CITY OF ALBUQUERQUE

**Re: ITT Building Addition, 5901 Indian School Road NE, Grading and
Drainage Plan**

Engineer's Stamp dated 4-04-05 (J18-D34)

C-1

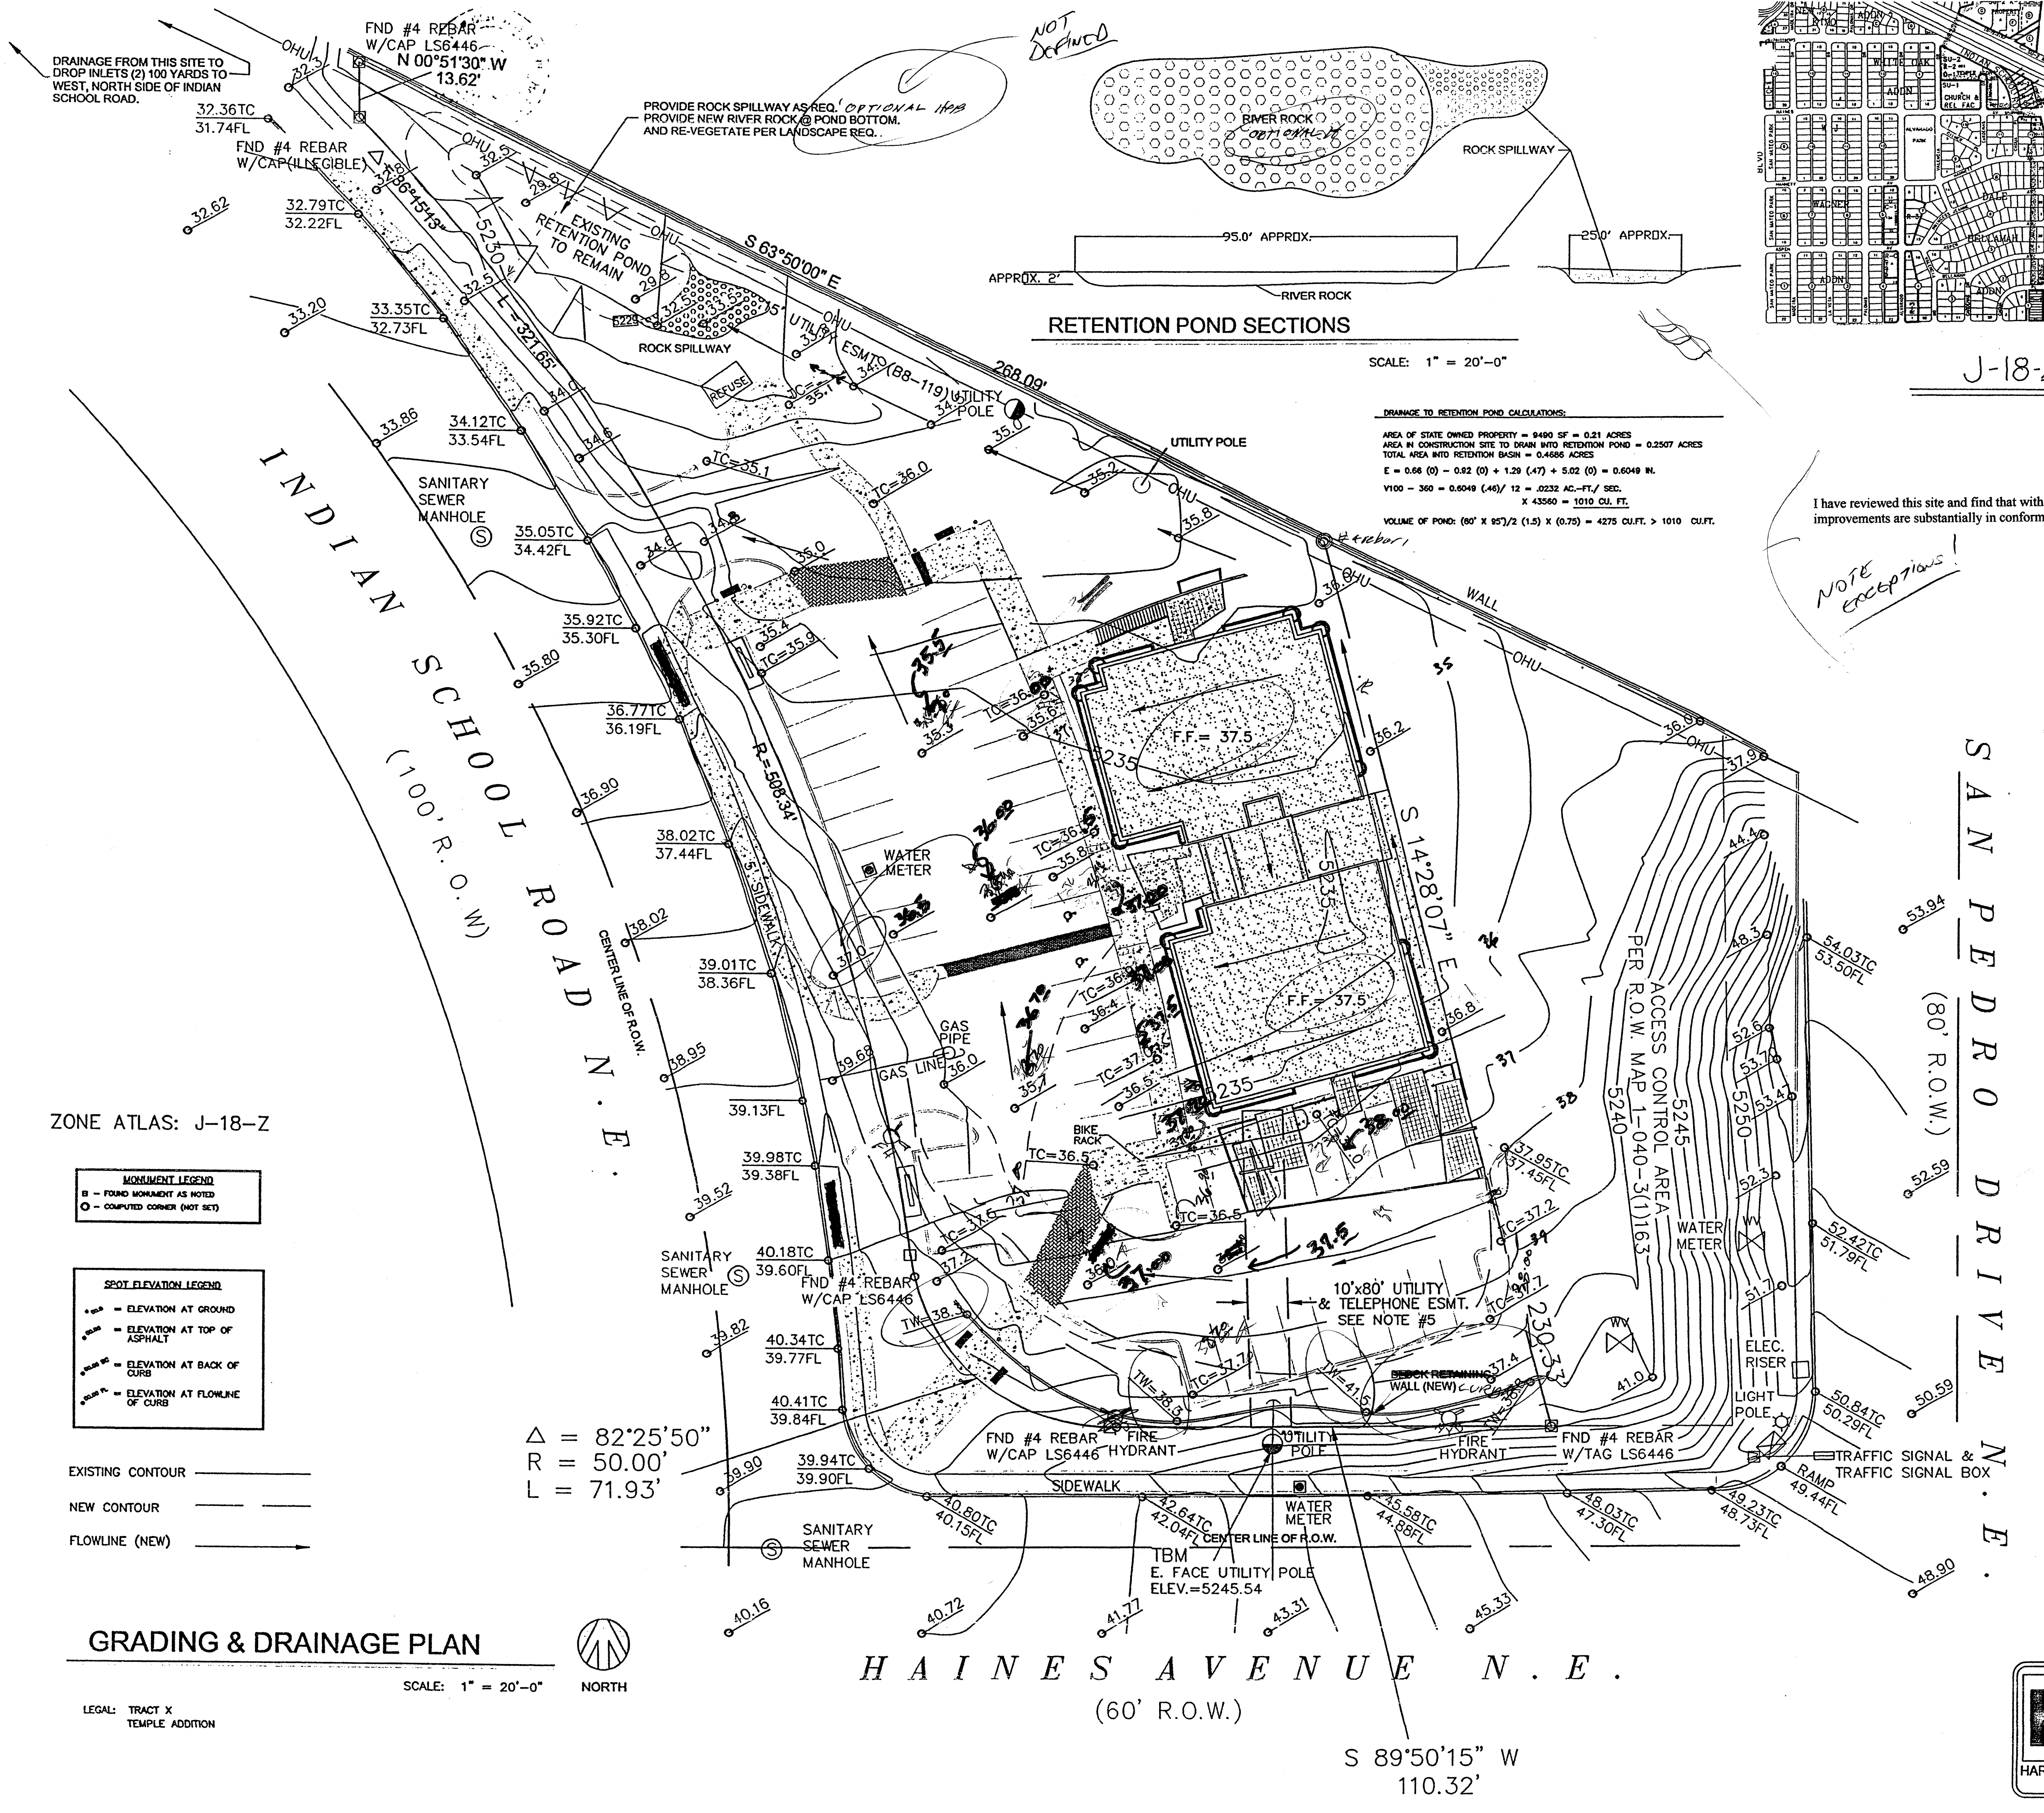
1. What is the actual area of the drainage? Within the plan, 4 different areas are shown, varying from 0.9974 to 1.6547 acres. Please check your calculations and write up for consistency and accuracy.
- ✓ 2. The current calculations refer to land treatments C1 and C2. According to the DPM, there is only one land treatment in the C category.
3. Calculate the proposed peak discharge for the entire project area. The 100-year, 10-day volume must be analyzed for the access control area in order to size the retention pond.

Why
don't
the areas
match?

Write up indicates
the area = 0.9974 Acres
